**KIRKLEES METROPOLITAN COUNCIL  
INVESTMENT & REGENERATION SERVICE**

Reference No:	<b>2024/62/93080/W</b>
Site Address:	Bath Works, Lamb Hey, Spa Lane, Linthwaite, Huddersfield, HD7 5QB
Description:	Formation of access, re-grading of land levels within the site and associated engineering operations
Recommending Officer:	Lucy Taylor

**DECISION – CONDITIONAL FULL PERMISSION**

## **Officer Report.**

Title
Site plan and sections.

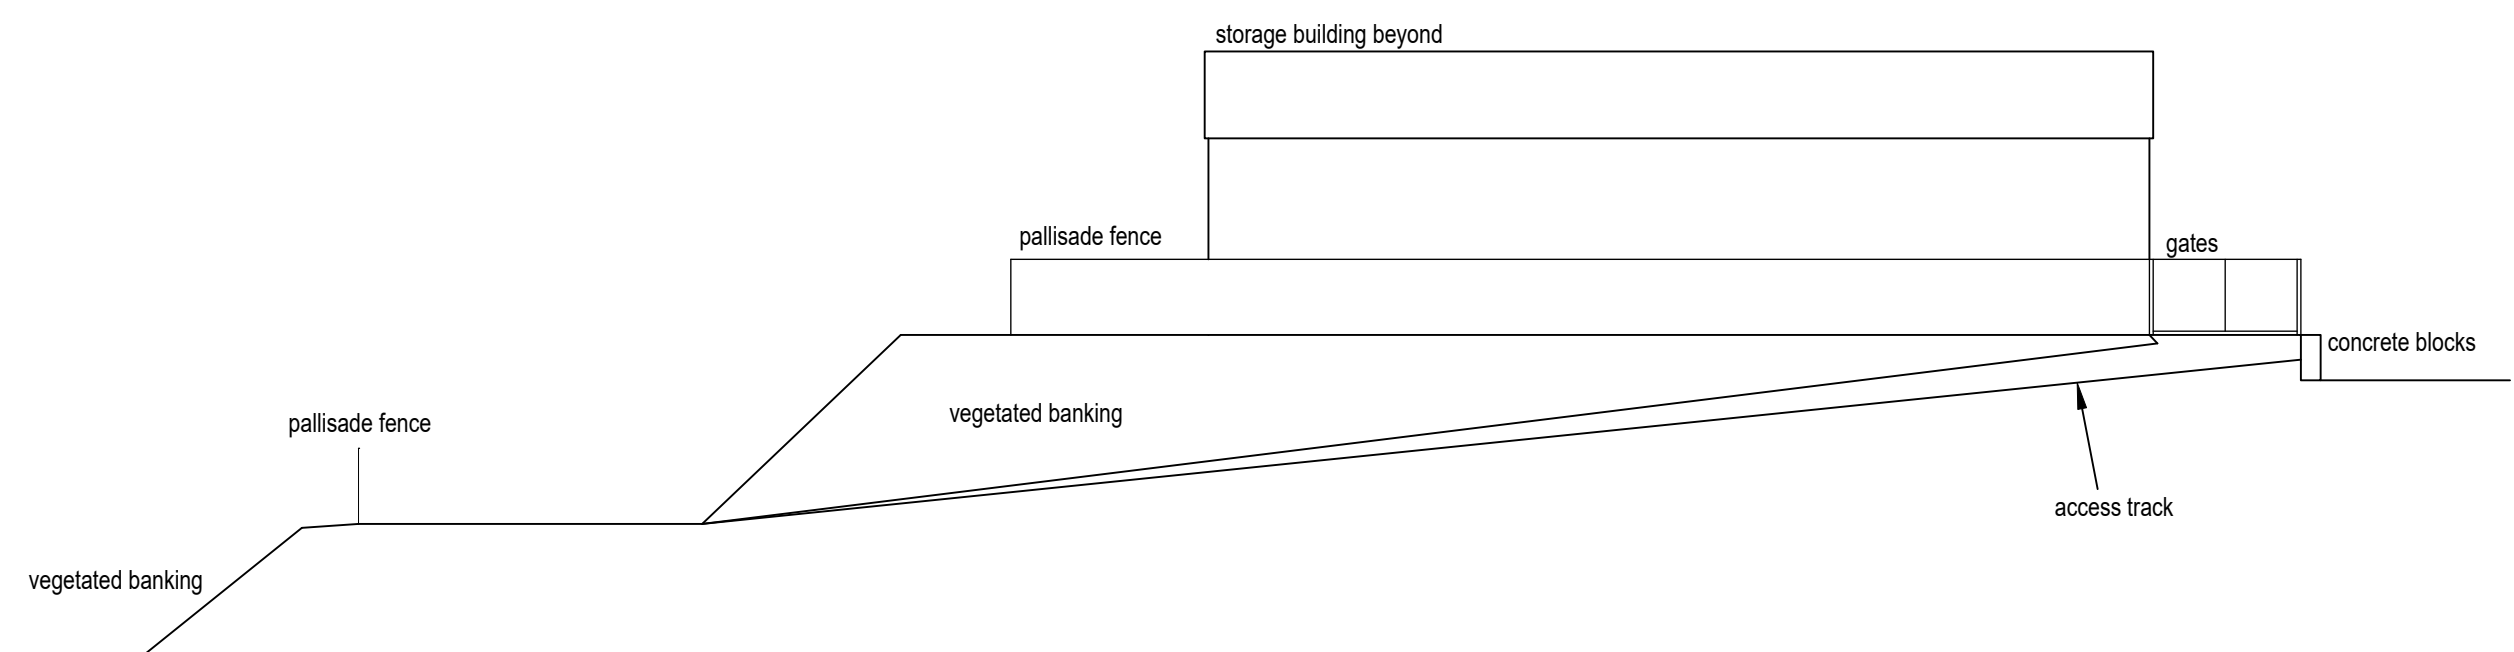
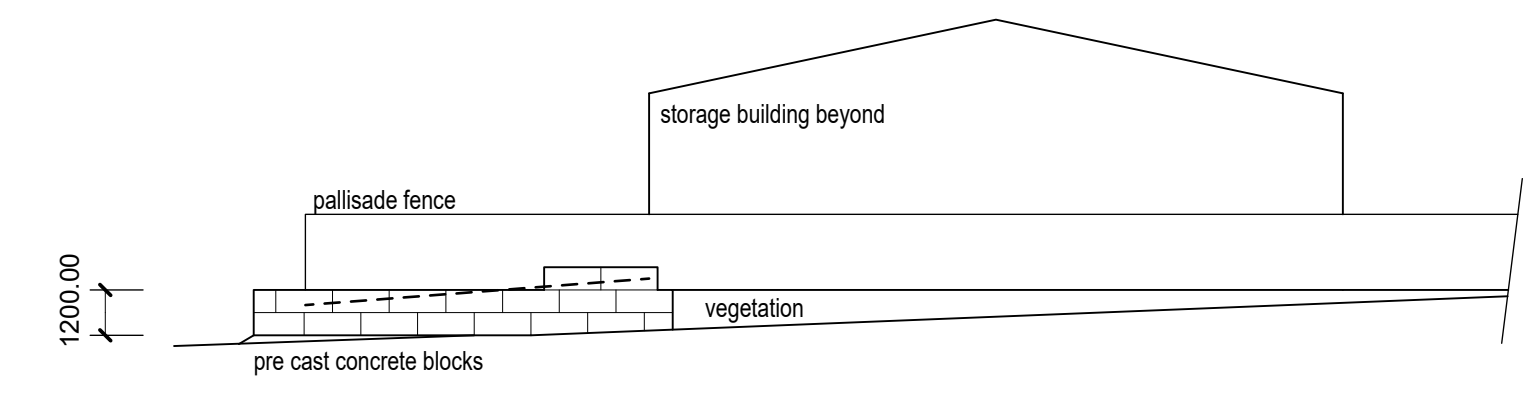
The case officer also requested that the planning agent submit details of land stability / retaining structures, including elevation and section drawings. In response to this, the planning agent submitted the drawing titled 'New access route', Dwg No. 10A.

*Further to the additional dimensions provided for the retained height of the proposed retaining wall adjacent to Spa Lane, I would like to advise that this is relatively small and as such no structures condition is required.*

2. There shall be no vehicular parking and / or external storage undertaken within the area annotated 'access track' upon the submitted drawing titled 'Site plan and sections' ref 10B at any time.
